Our Ref: R/268/17/PL
Your Ref:

Town & Country Planning Act 1990 (as amended)
Town and Country Planning (Development Management Procedure) (England) Order 2015
Application for Planning Permission

Development Refurbishment of existing single storey building for community use, including elevational changes.
Location WRVS Centre Broadmark Parade Broadmark Lane Rustington

EXISTING SITE PLAN 1:200

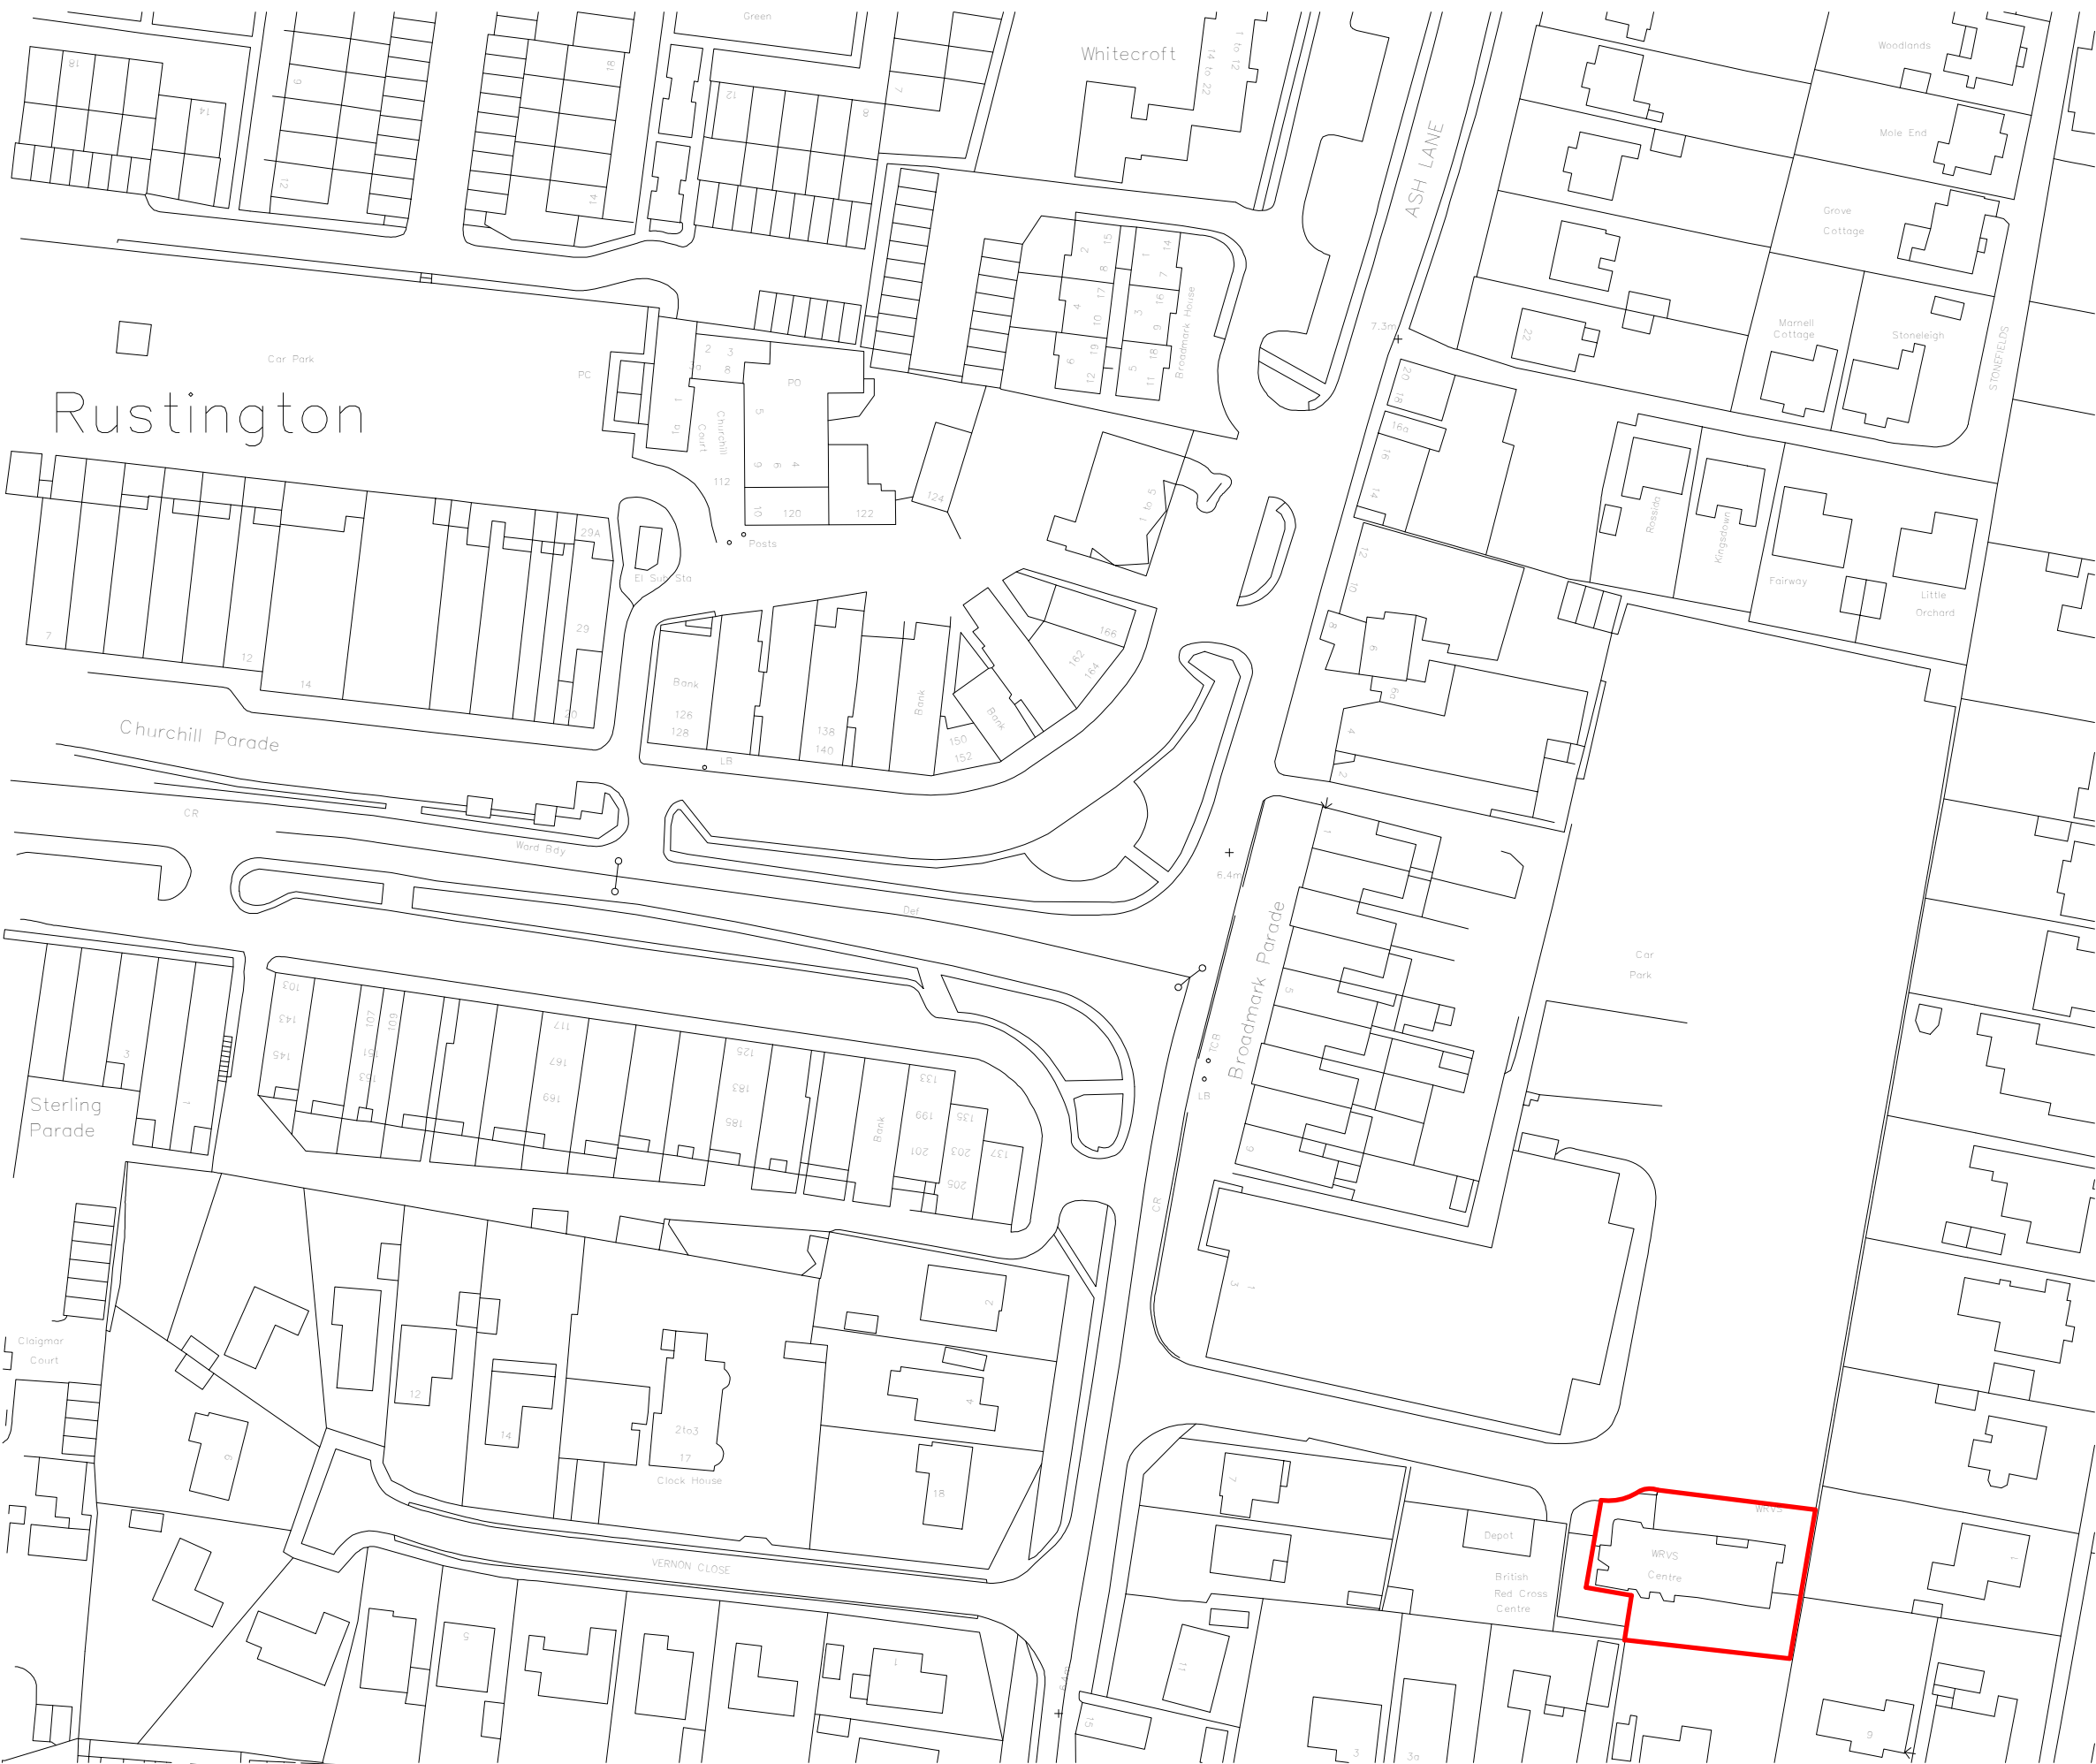
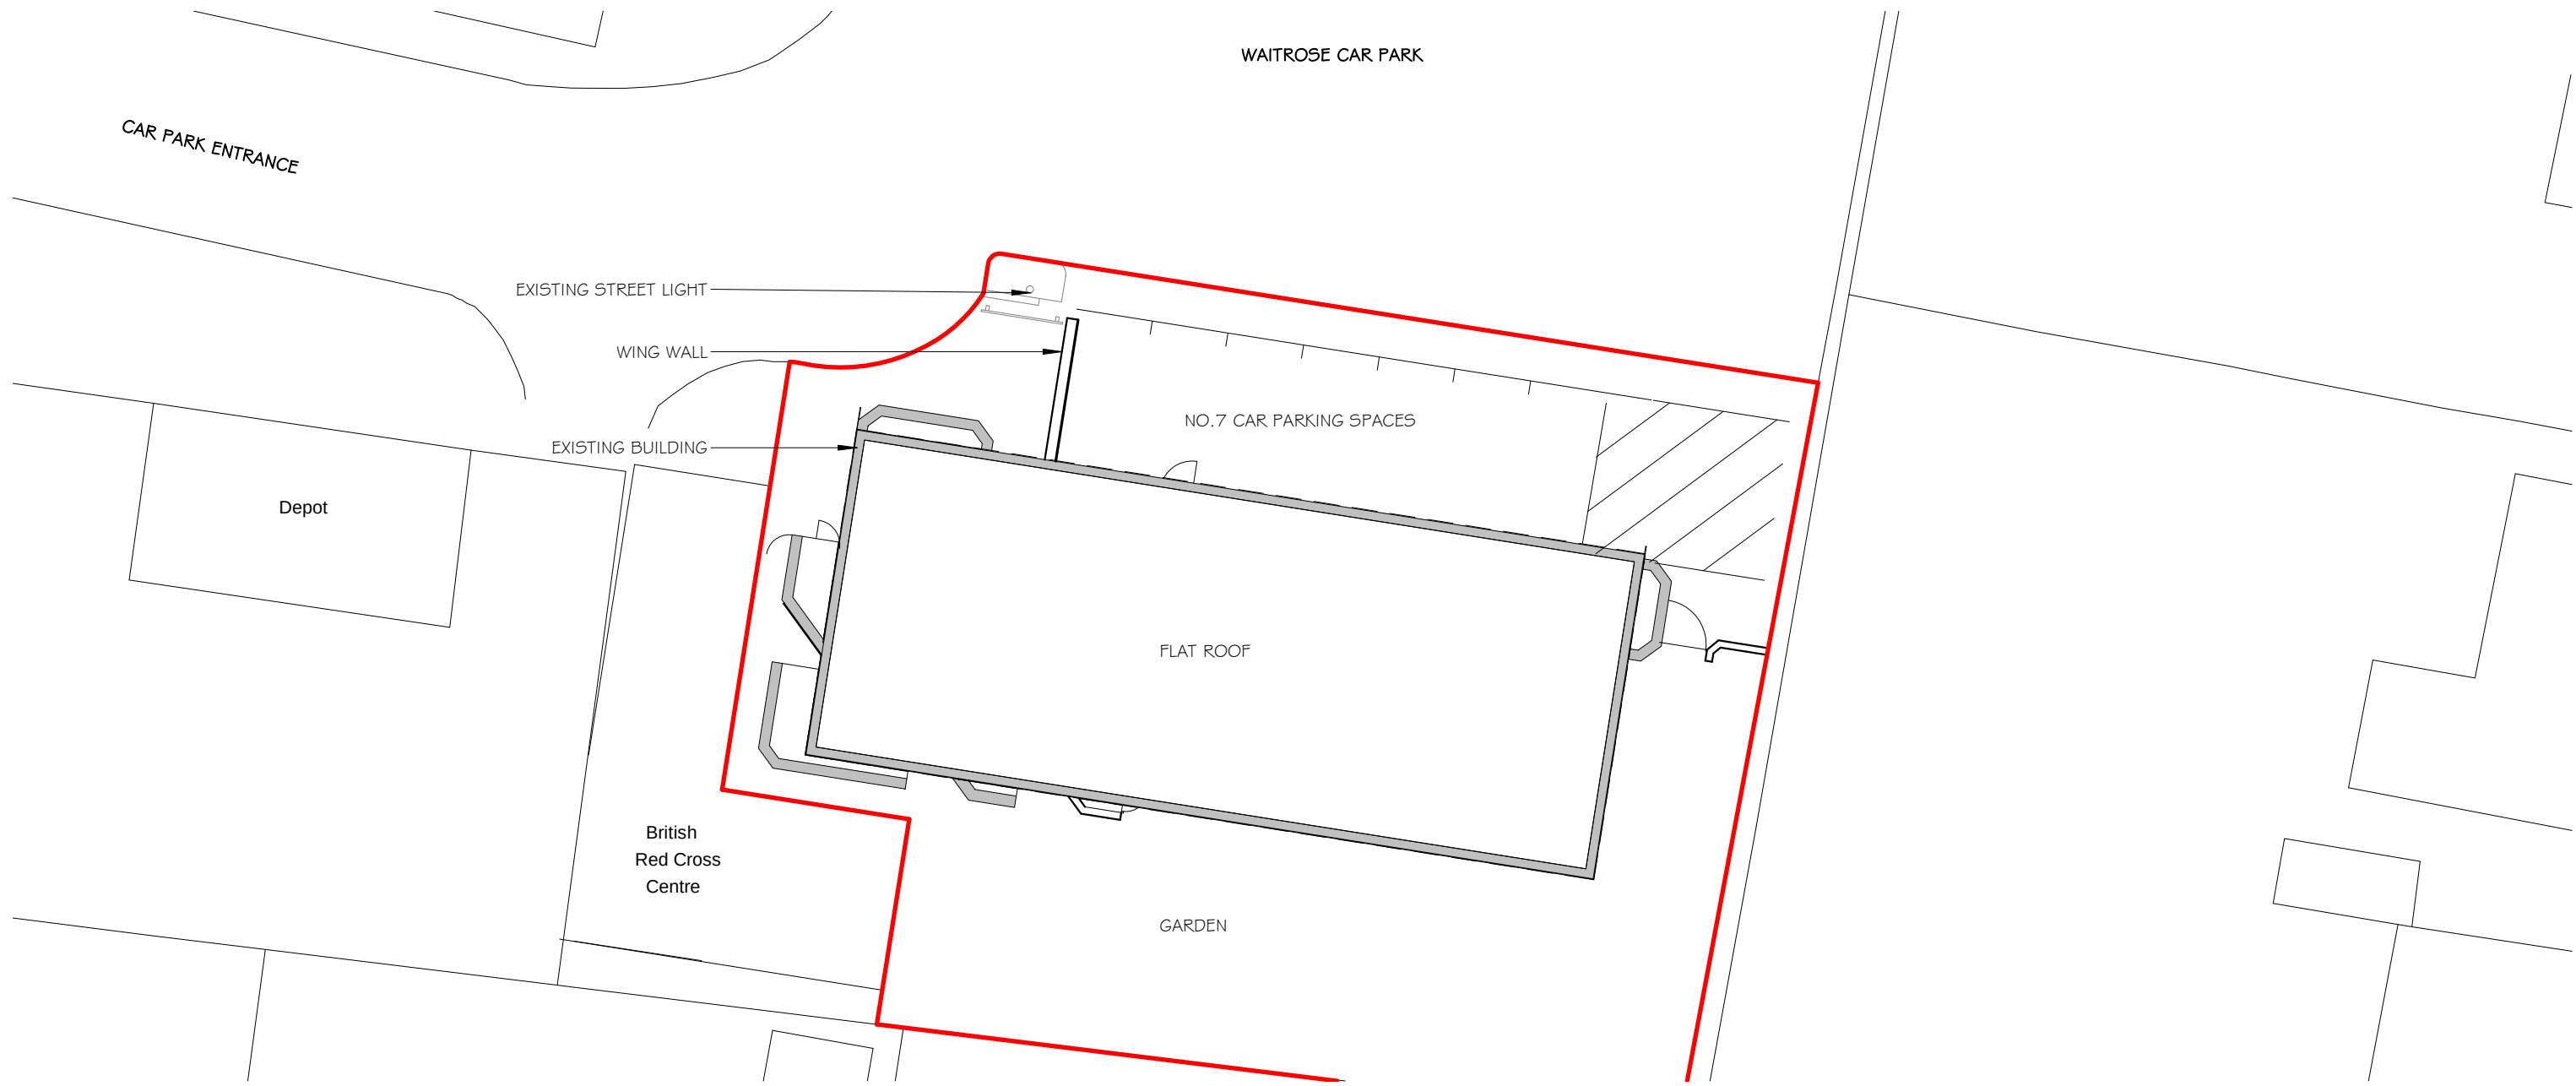
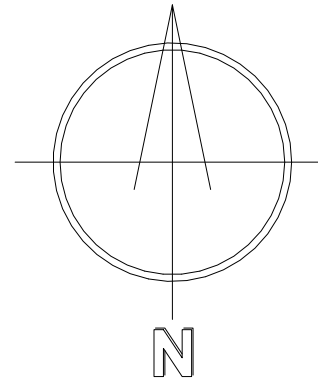
The existing site plan, block plan and location plan do not scale correctly. Please amend accordingly.
